Site:	Oldlands Farm
Client:	Panattoni UK
Job Number:	784-B071527
Date of Submission:	July 2025
File Location:	\lds-dc-vm-101\Data\Projects\784-B071527_Oldlands_Farm_Phase_3_\60_Output\63_Published\

RE: BE/16/25/RES Land at Oldlands Farm Newlands Road Bognor Regis PO22 9NN

Following submission of the BES (Tetra Tech) to discharge Condition 18 and the LEMP (Tetra Tech) to discharge Condition 19 of the Arun District Decision Notice (BE / 150 / 22 / OUT), the following LPA comments have been received:

DRAWING TITLE
**DETAILED PLANTING PLAN
(Sheet 1 of 2)**

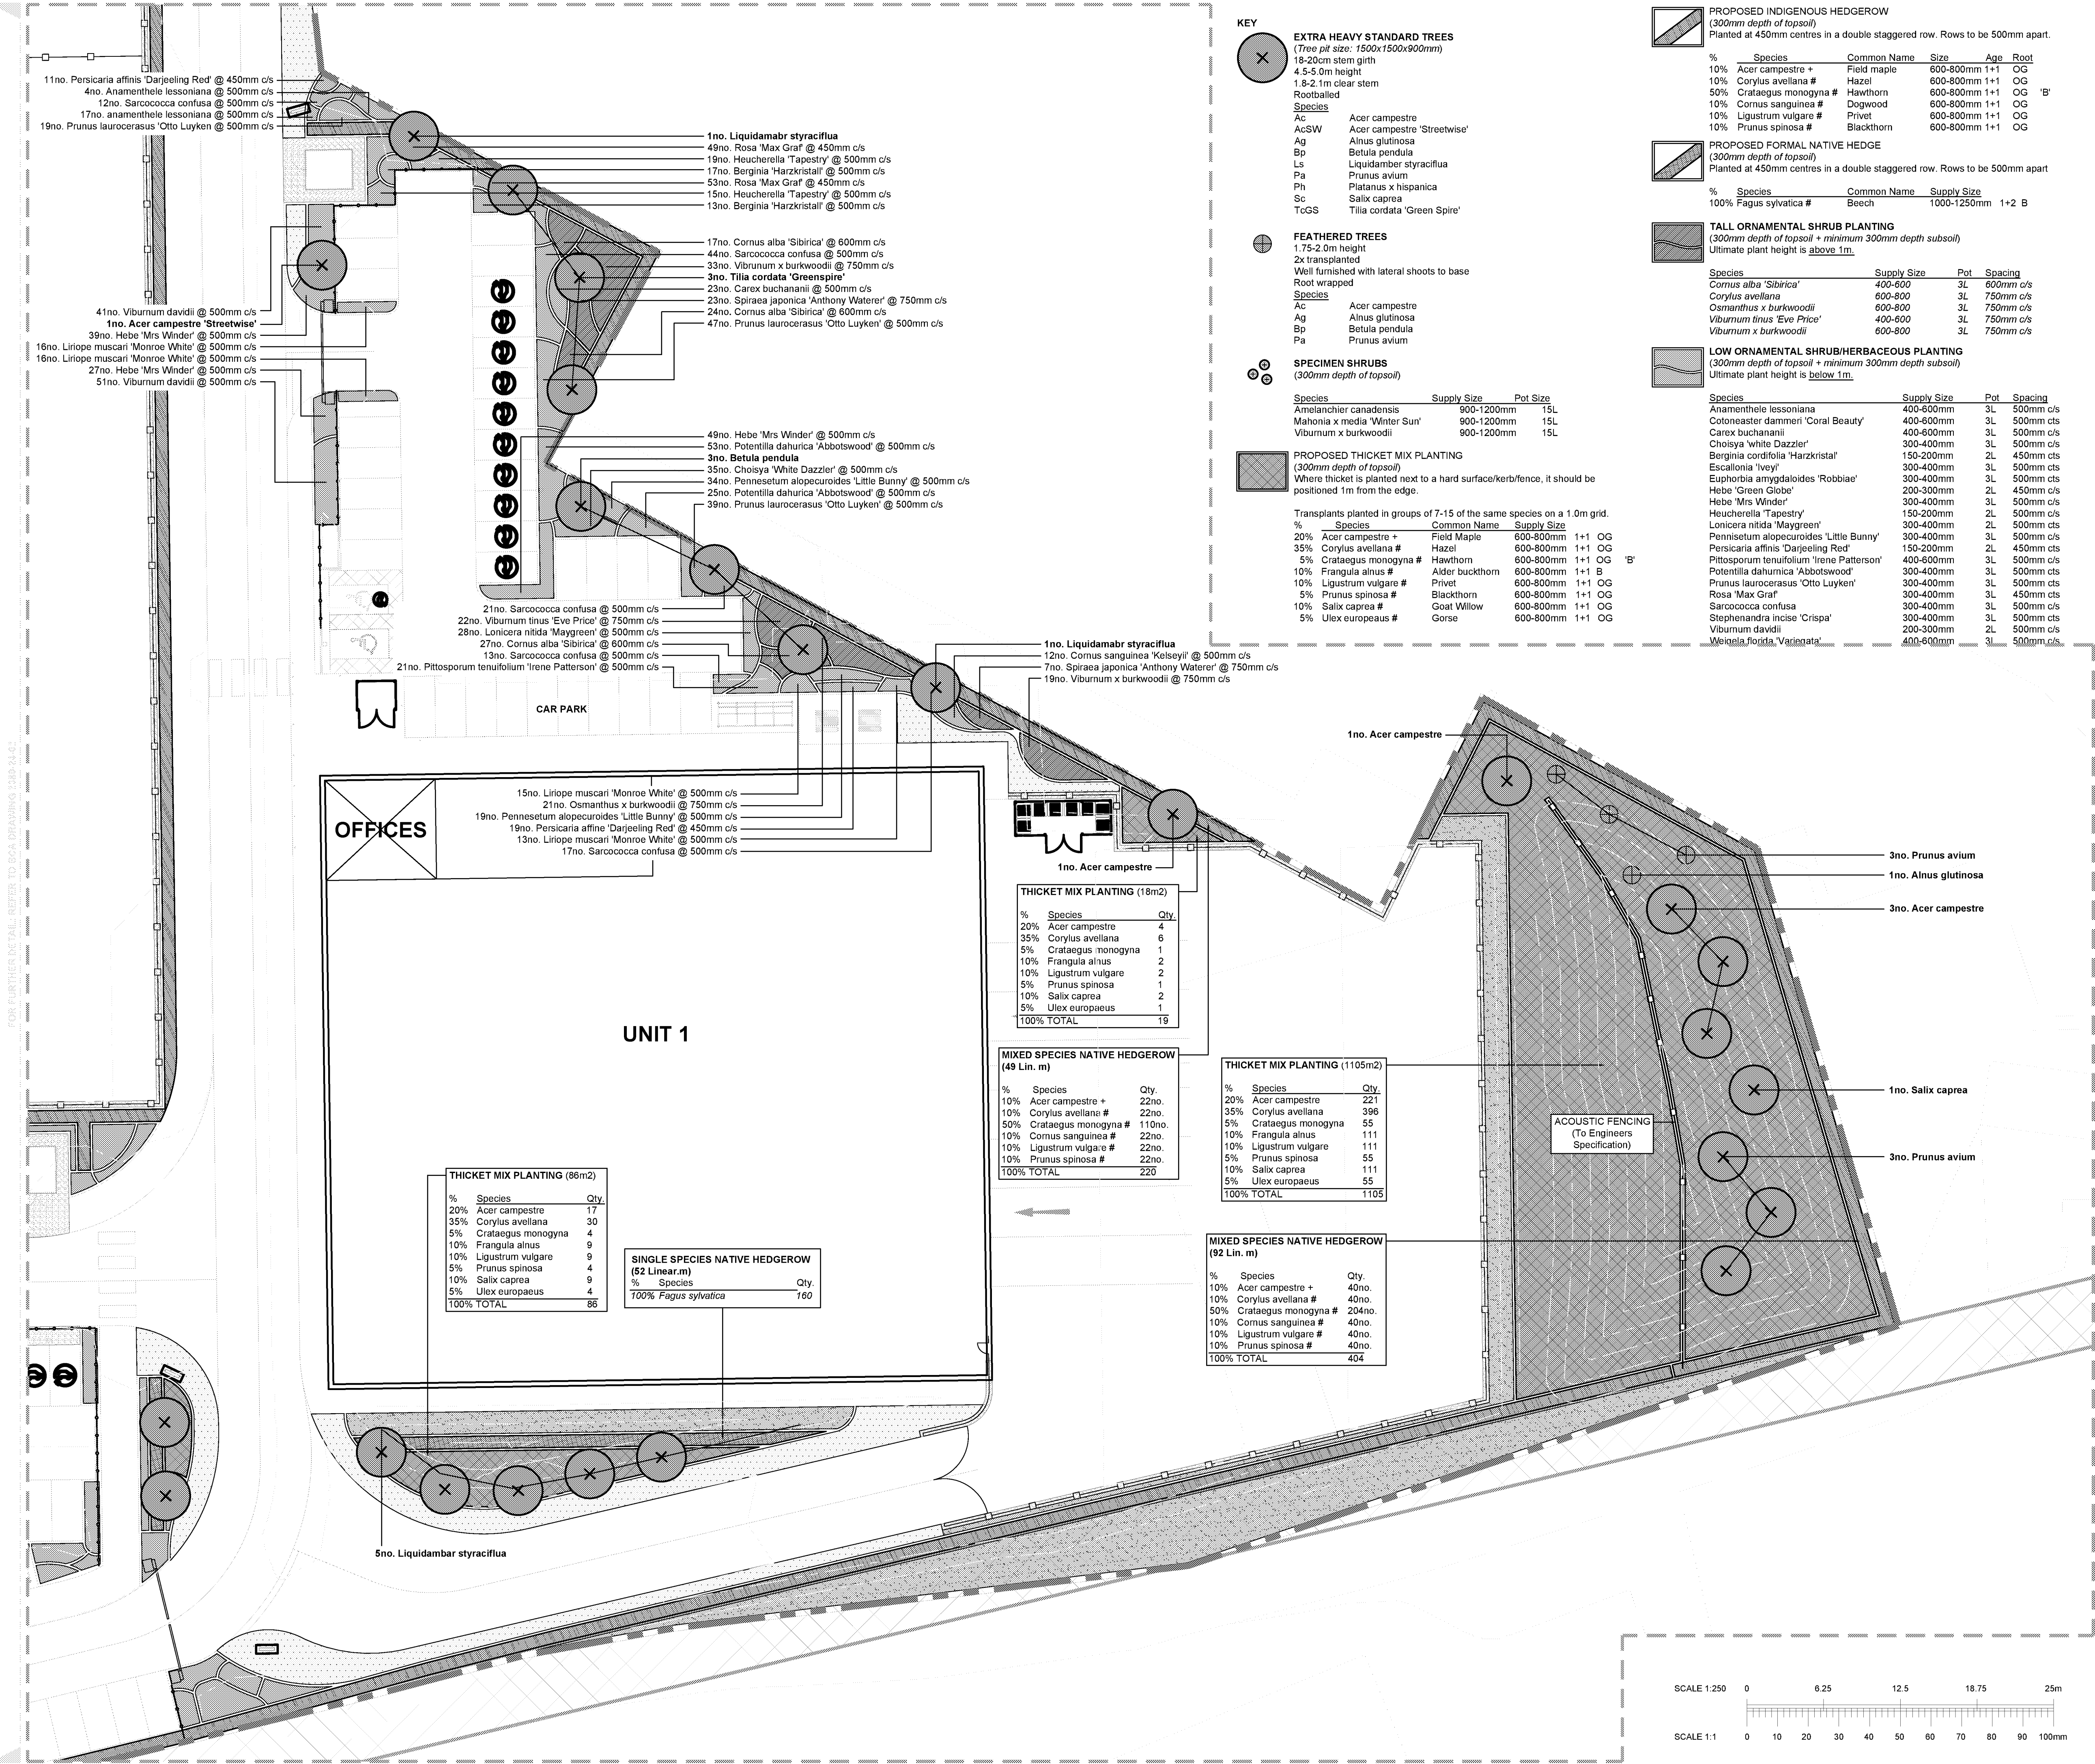
- *Because of the hedges shown on the plans, access for maintenance of the grass areas require review as it looks as if it would be very difficult to maintain grass areas on the southern end of the site without breaking through a hedge.*

The landowner (Panattoni) has access to land to the south of the proposed hedge which provides sufficient access for management and maintenance, and this will be accessed by the management company.

Ecological Enhancement Plan

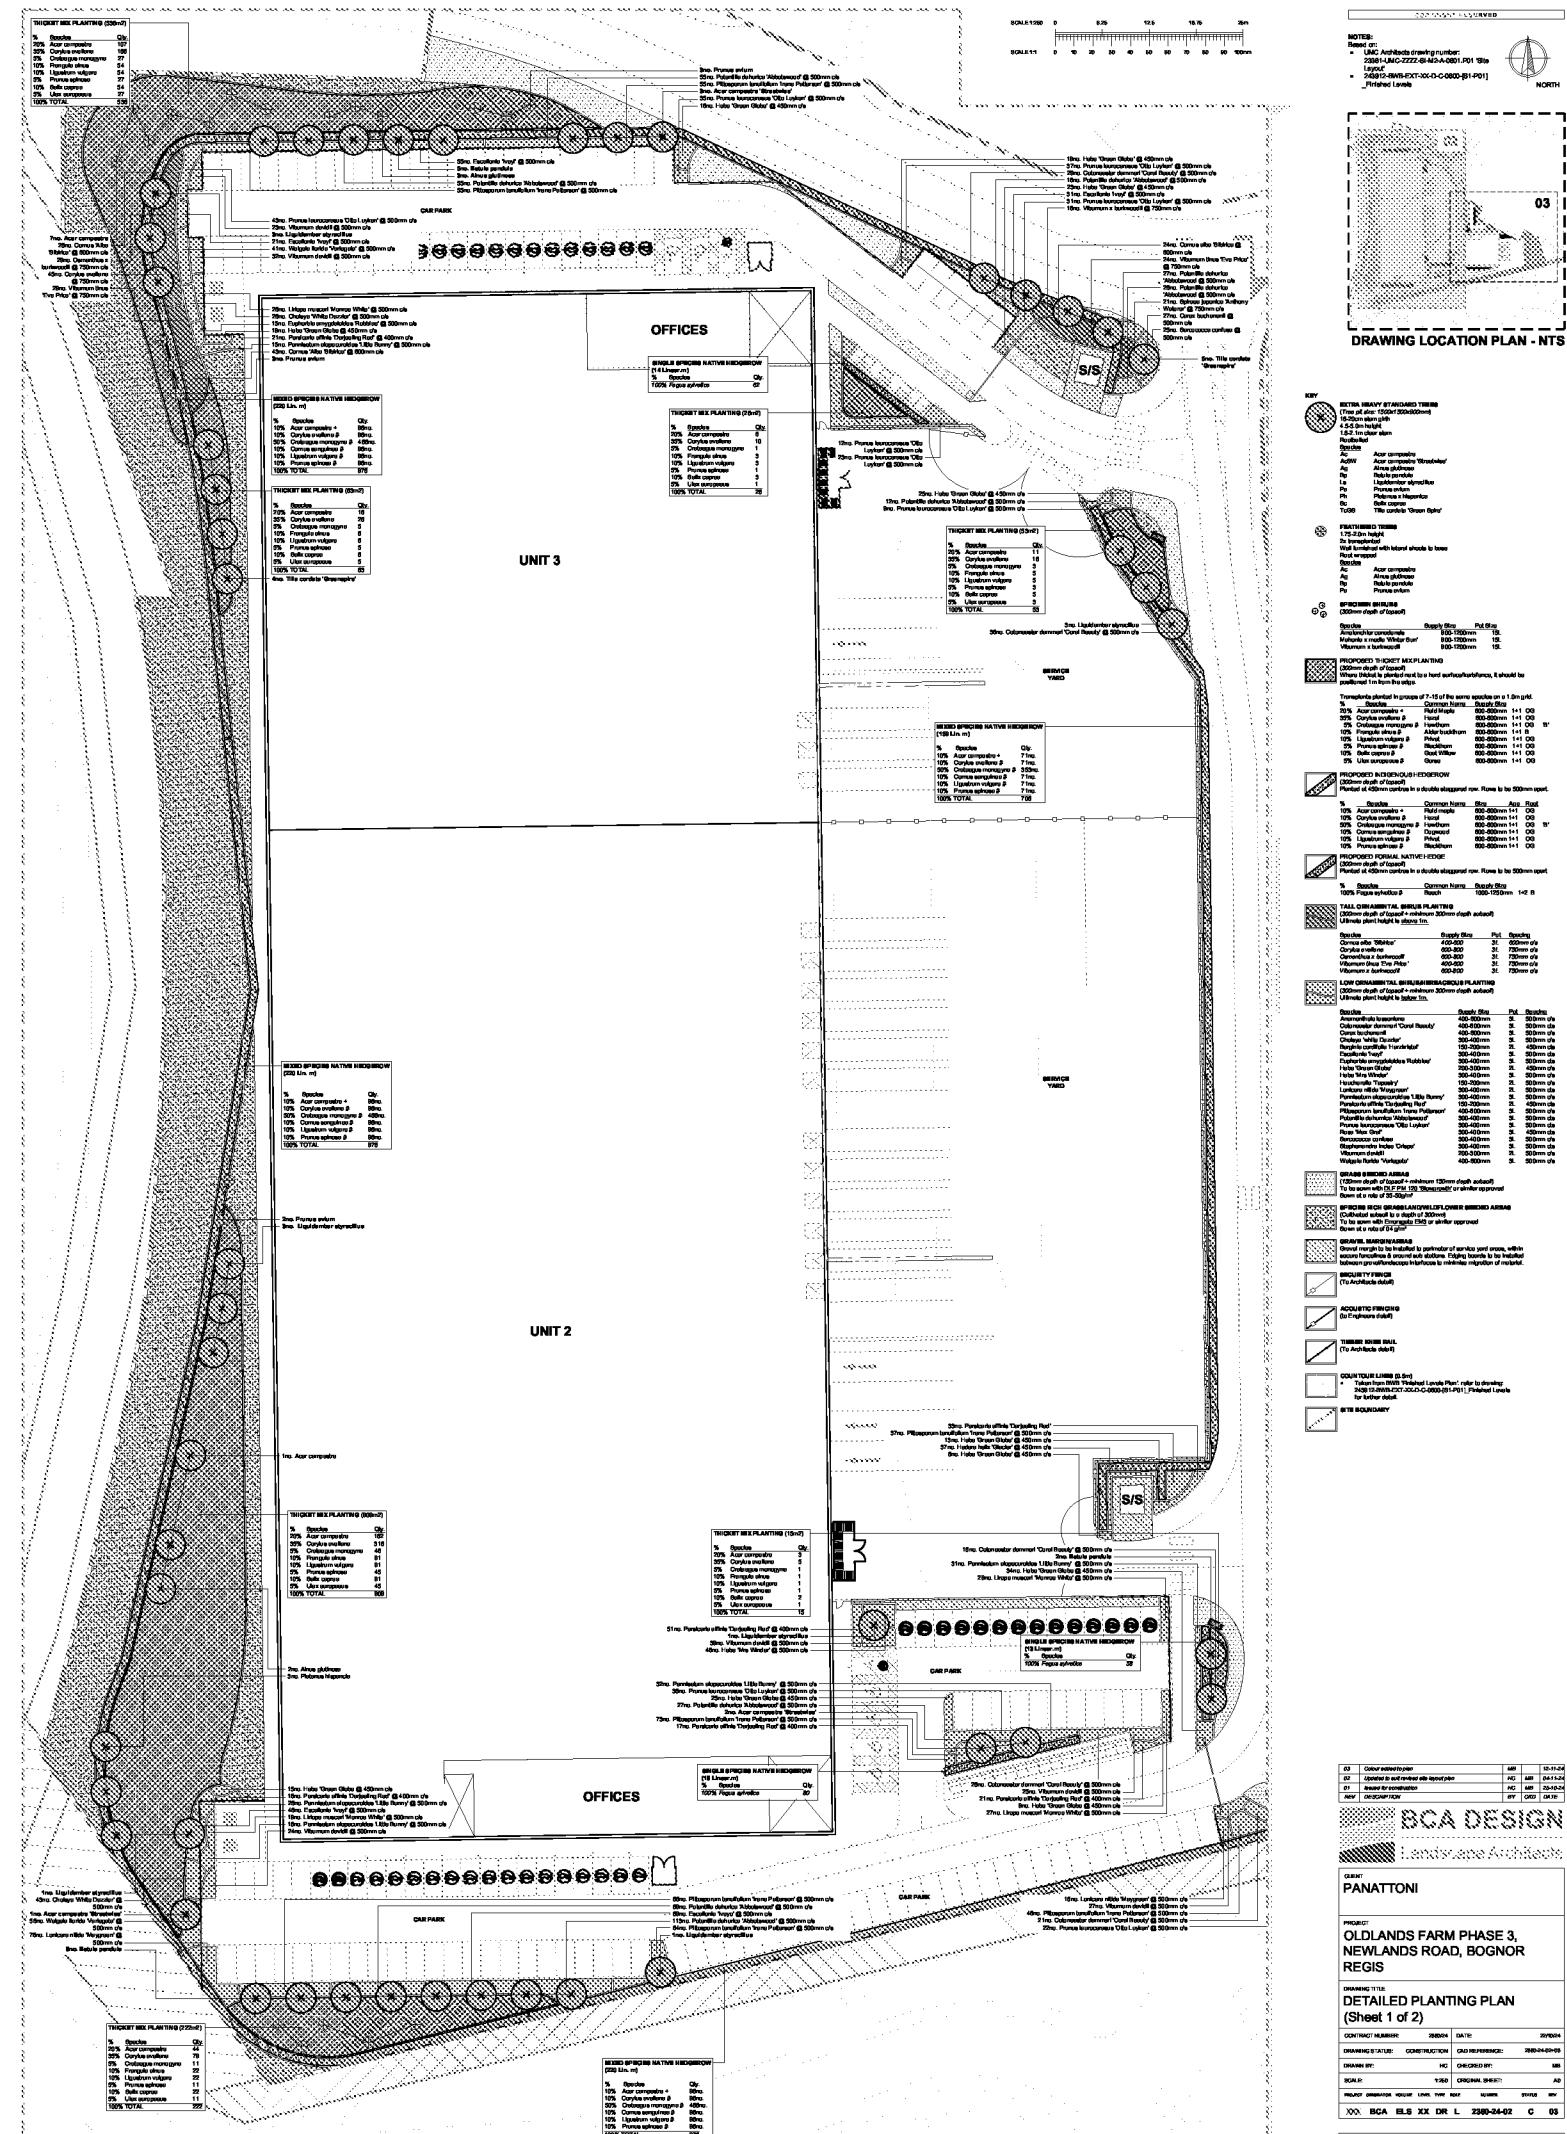
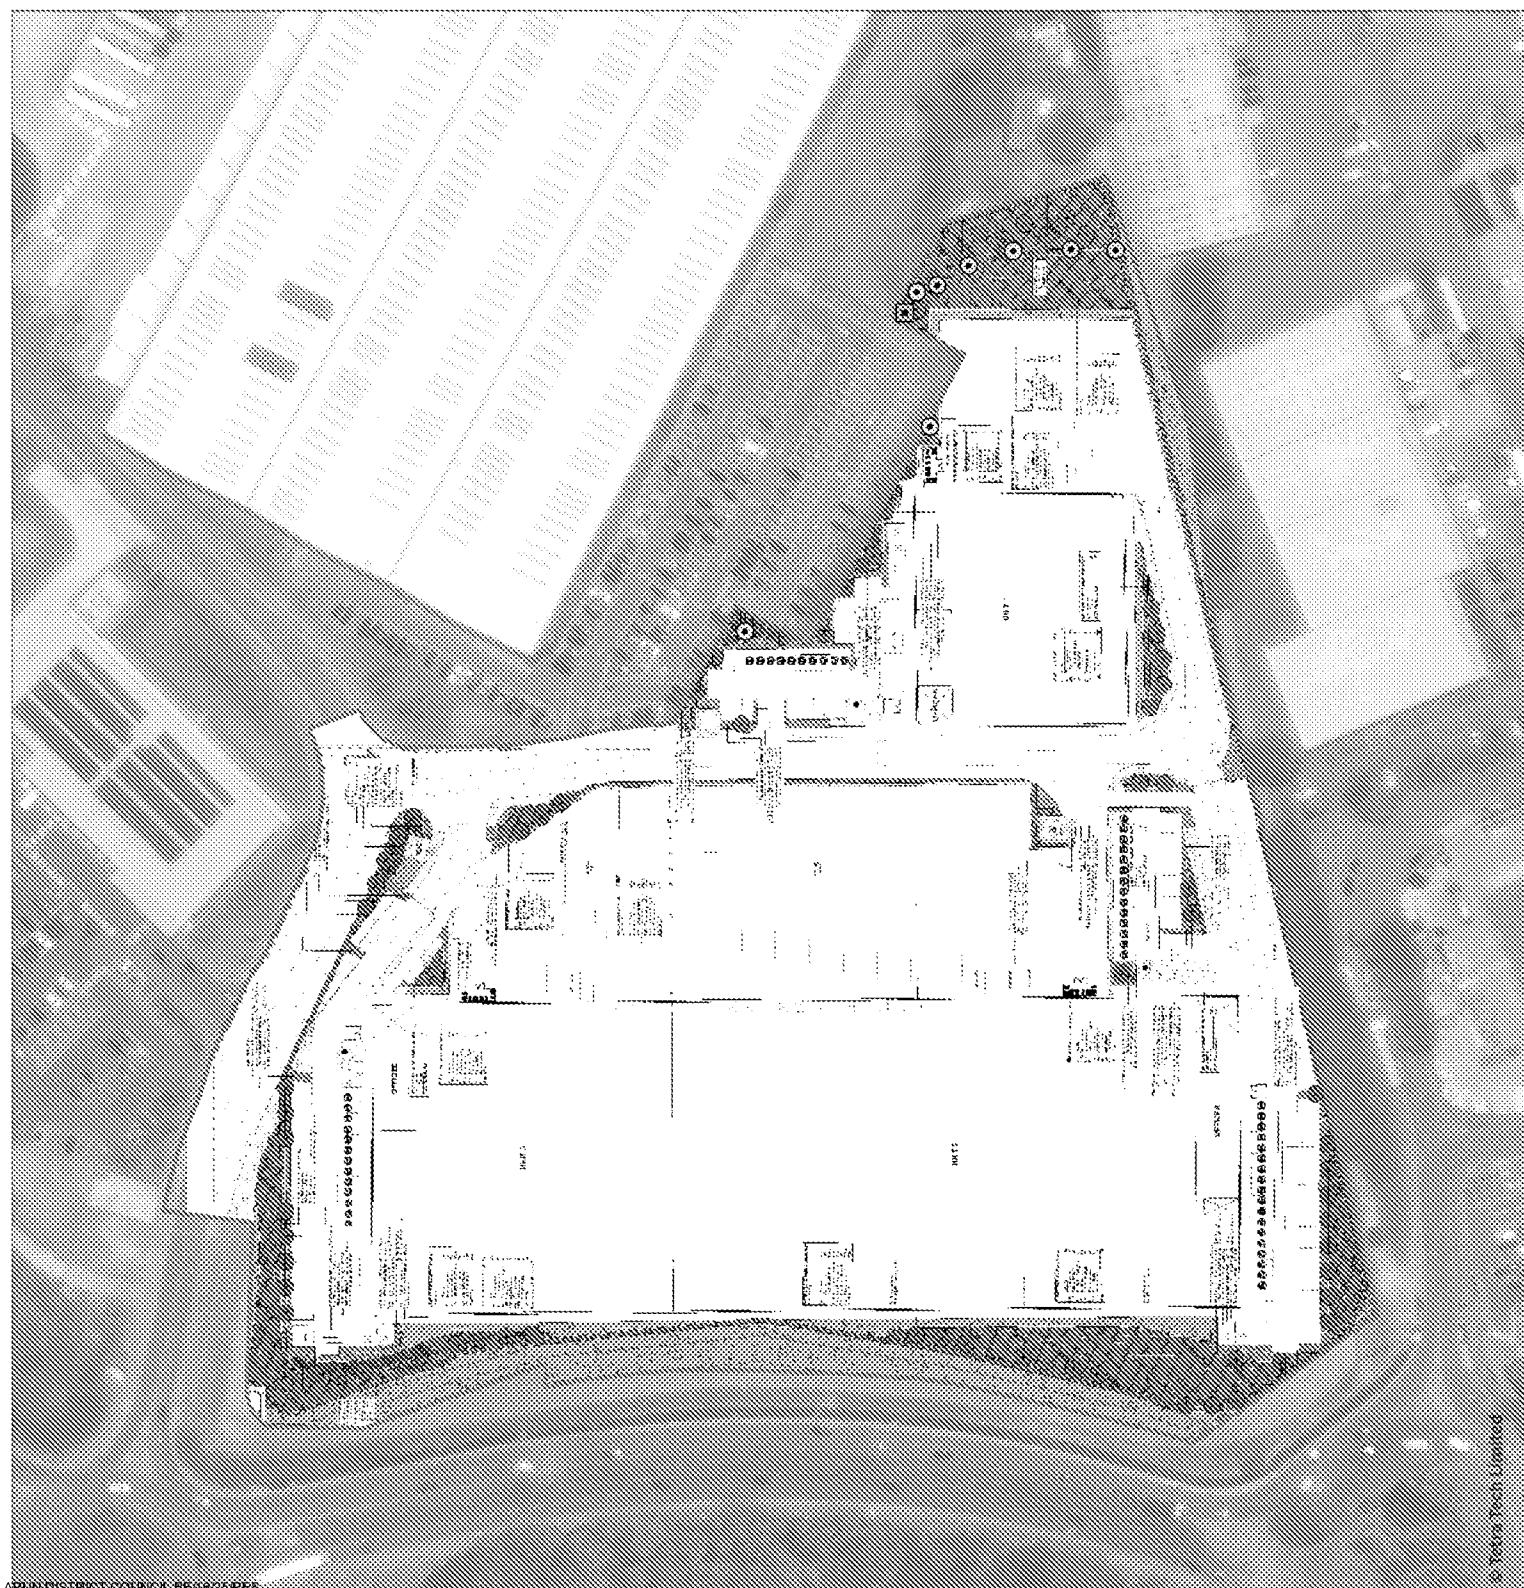
- *The provision of no less than 8 new features for roosting bats, including three cavity wall boxes such as the Habibat Bat Box or Vivara Pro build-in WoodStone bat box, three crevice roosting features for buildings, such as the Schwegler 2FE wall mounted shelter or Beaumaris woodstone bat box and two tree mounted bat boxes, such as the general purpose bat box.*
No wall mounted cavity bat boxes and only 3 tree bat boxes are shown on the plans. This falls short of the requirements.

- *The provision of 10 new features for nesting birds, including 2 swift boxes, 2 house martin cups, 2 house sparrow terraces and 4 general purpose bird boxes.*
Only 4 General purpose nest boxes are shown in the Biodiversity Enhancement Strategy February 2025. This falls short of the requirements.

The building design is not suitable for using built in bat boxes. The BES (Tetra Tech, 2025) shows that four bat boxes are installed on poles (2 per pole) within the southeastern corner of the site. This is located in the part of the site where native scrub planting is being created and is connected to suitable commuting and foraging habitats off site. This is considered to be an appropriate enhancement for roosting bats within the site.

The building design is not suitable for using building mounted bird boxes. The BES (Tetra Tech, 2025) shows the four general purpose bird boxes being installed within appropriate areas around the site. The proposed native scrub planting as part of the landscape design will provide a significant amount of suitable nesting habitats for birds so will be a significant enhancement. Although the building mounted boxes are not able to be installed the general-purpose bird boxes and scrub planting will significantly enhance the site for nesting birds.
